Development: Approval of details reserved by condition imposed under
BR/208/14/PL

Location: 65c Gravits Lane Bognor Regis

Ref: BR/112/18/DOC
Condition No. 3

Please find enclosed information in regards to your engineer's comments relating to Condition No. 3 – Surface Water Drainage:

LOCATION PLAN
65C GRAVITS LANE BOGNOR REGIS

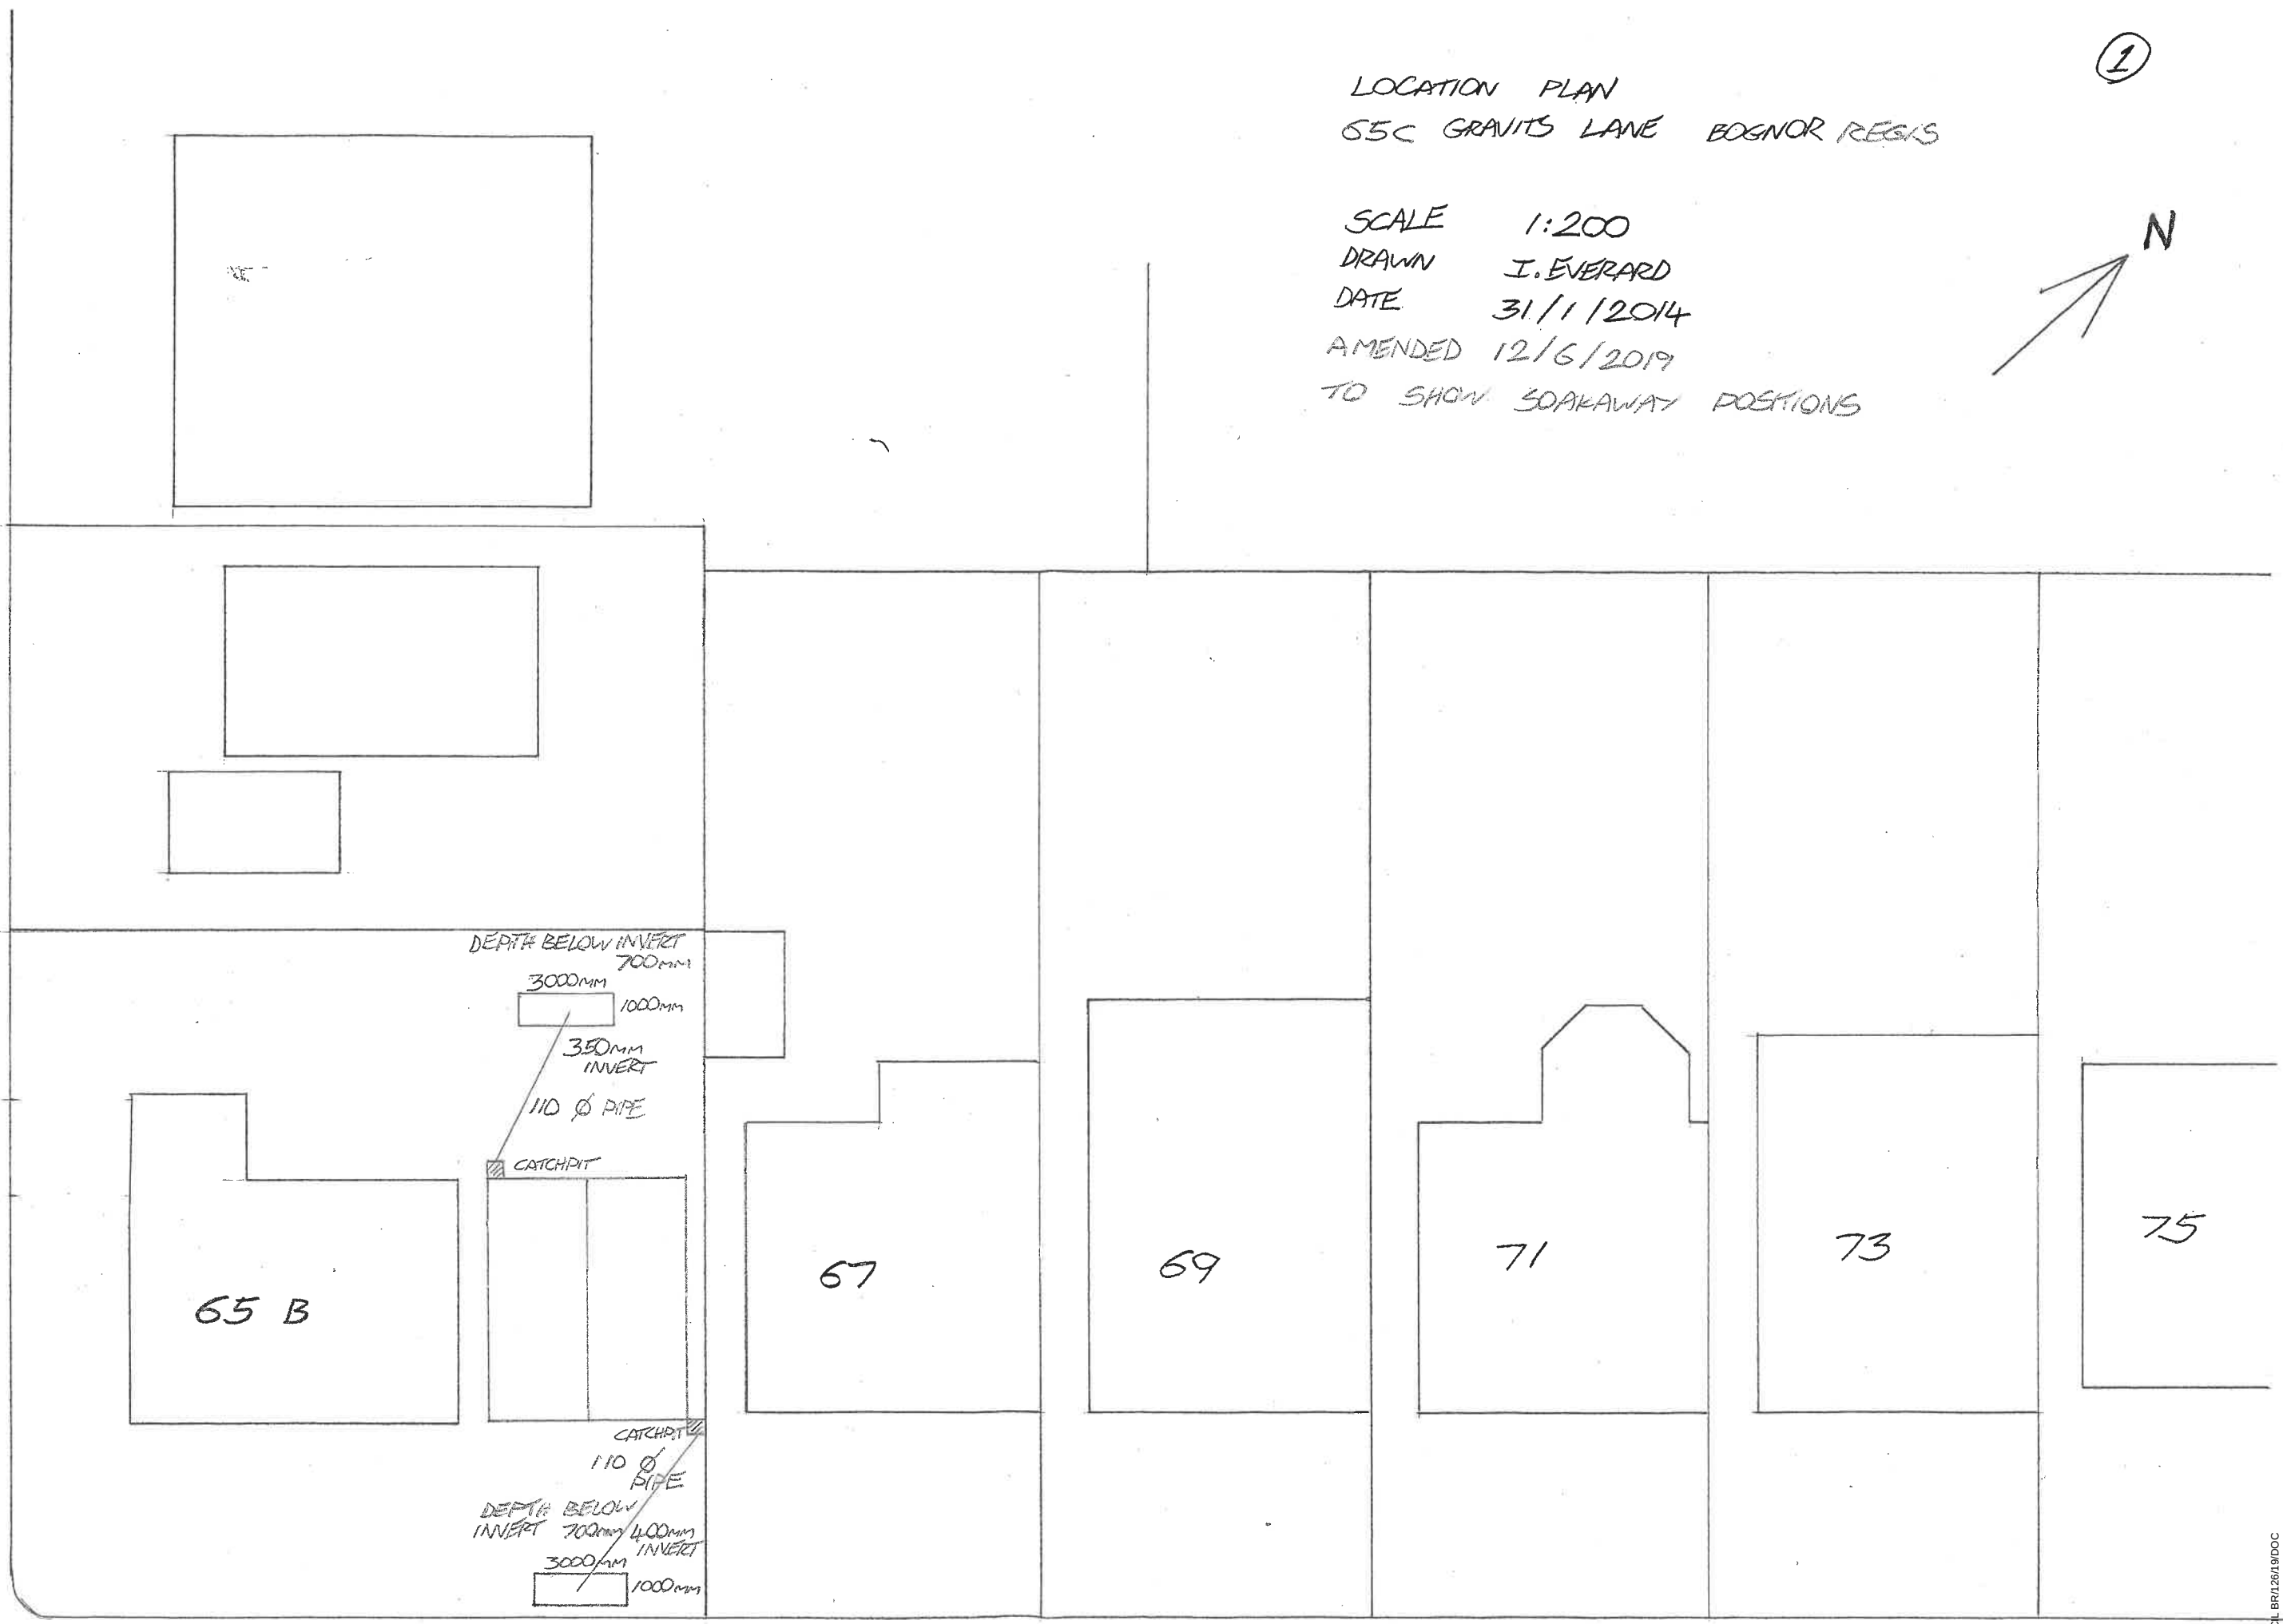
- Please see enclosed plan for position of the soakaway crates. Soakaway to the front garden will be 3 crates long x 2 crates high. Soakaway to the rear garden will be 3 crates side by side x 2 crates high. Both soakaways will have a maximum invert level of .4m using 100mm diameter underground drainage pipe. The assembled crates will be wrapped in Stratacheck plus non-woven geo textile.
- Each rainwater downpipe will have a back inlet bottle gully to trap silt and leaves, etc.

FRONT AND REAR SOAKAWAY CONSTRUCTION
FOR G5C GRAVITY LANE BODNOR REG'S
W. SUSSEX

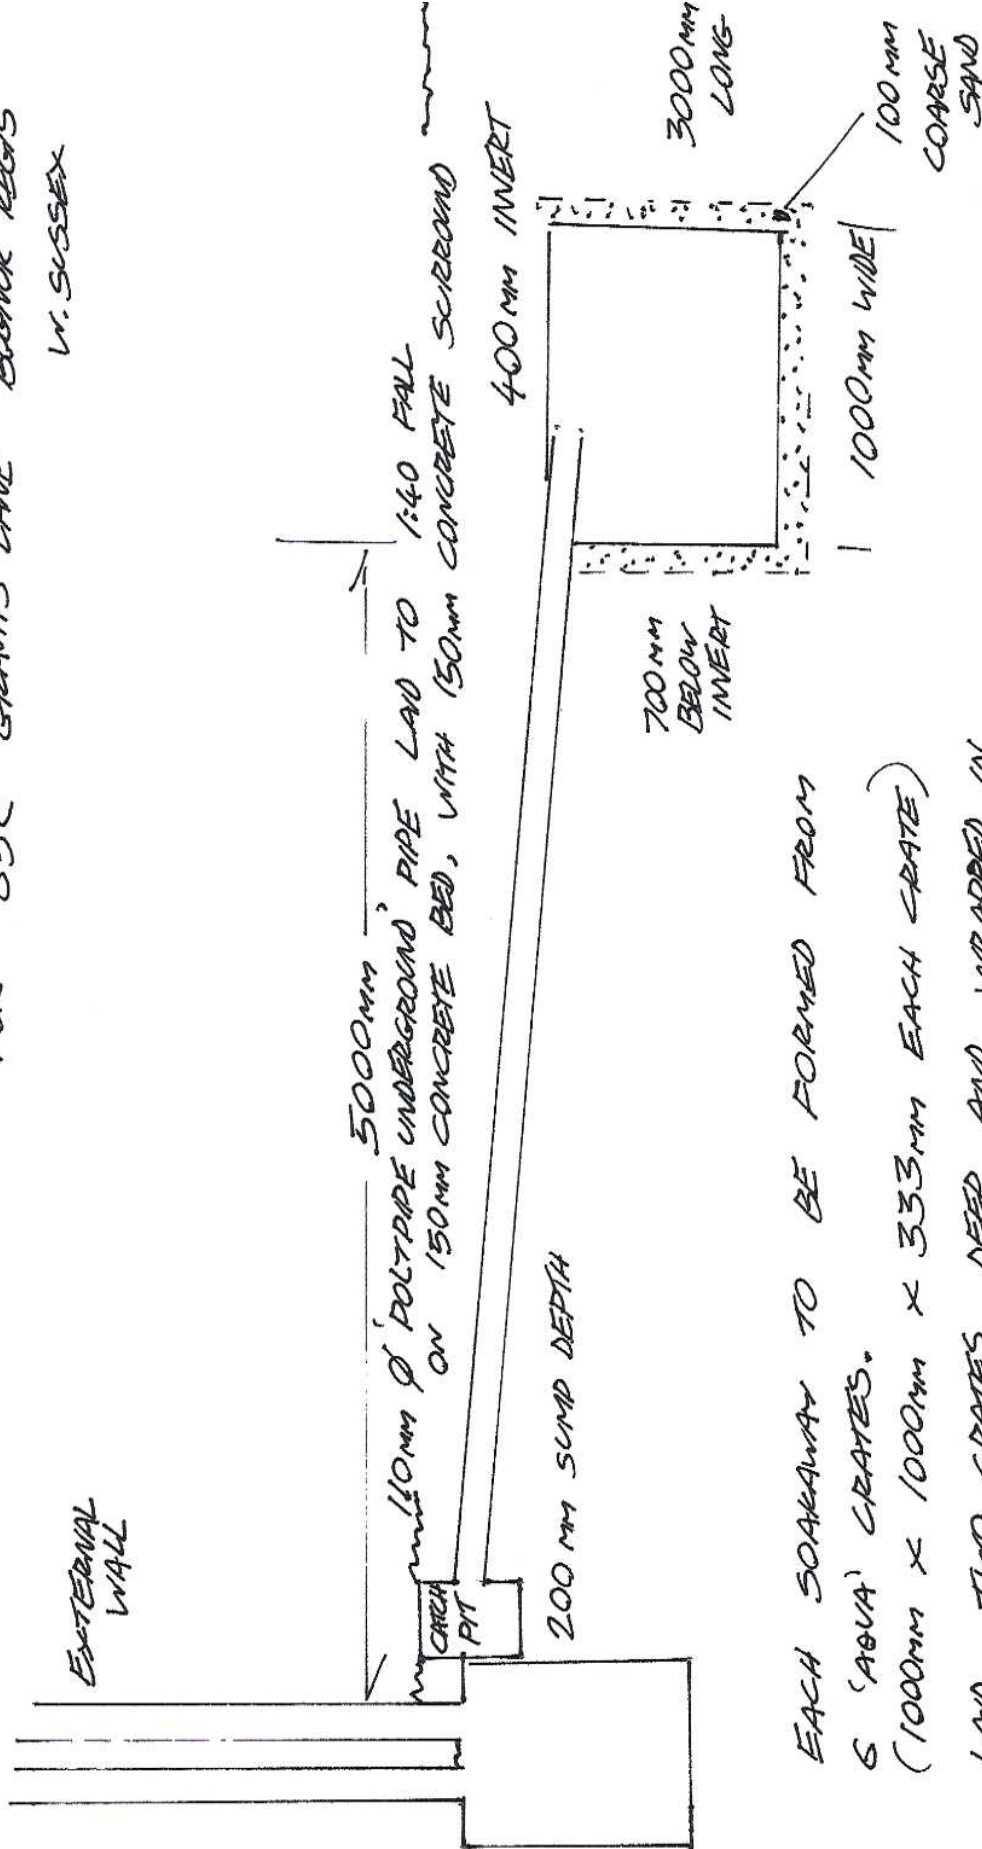
- Please see calculations re-submitted for a single soakaway (rubble-filled) showing a free volume of $.771\text{m}^3$. Proposed soakaways front and rear garden each consisting of 6 no. polystorm crates each being $.4\text{m} \times .5\text{m} \times 1\text{m}$ with a 94% void ratio giving a free volume of 1.28m^3 . Thus, overall, we will provide a free volume area of 2.256m^3 which is 293% of the calculated minimum requirement.

INFILTRATION CALC'S
LAND ADJACENT TO
65B GRAVITY LANE
BOGNOR REGIS

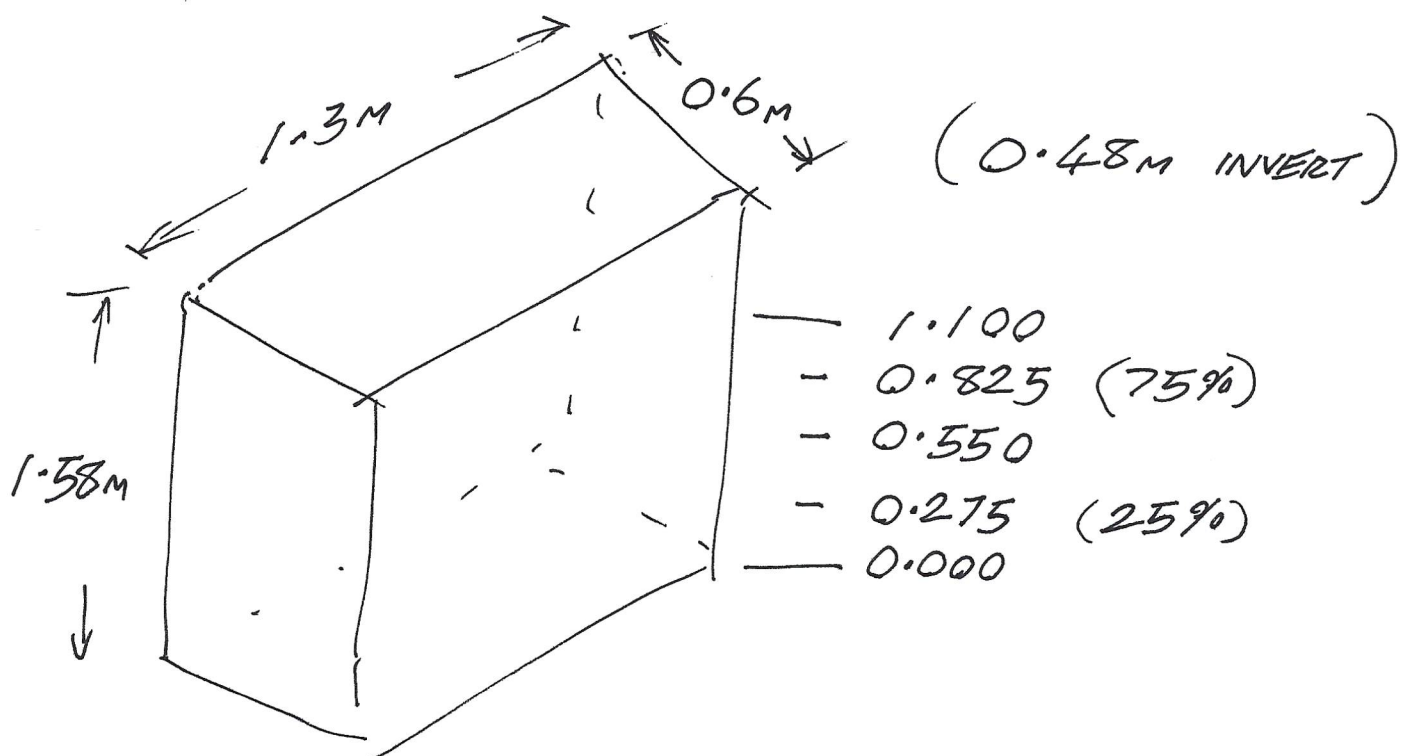
- Winter Groundwater Level – During excavations for the southwest section of footings (late July 2014), a trial pit was dug in the proposed back garden area approximately 1.58 metres below ground level. This pit was used to determine the soil infiltration rate (2.54×10^{-5} m / sec). An inspection by Arun District Council Building Control on or around 4 Aug 2014 would have seen this trial pit. A site hut for works for the adjacent property, 65 b, was adjacent to the trial pit. This was monitored on the enclosed dates (see enclosed sheet with on-site dates), and then weekly until 4 April 2016 when the remaining footings were excavated (inspected by Arun District Council Building Control) and placed. During this period, groundwater was not observed.
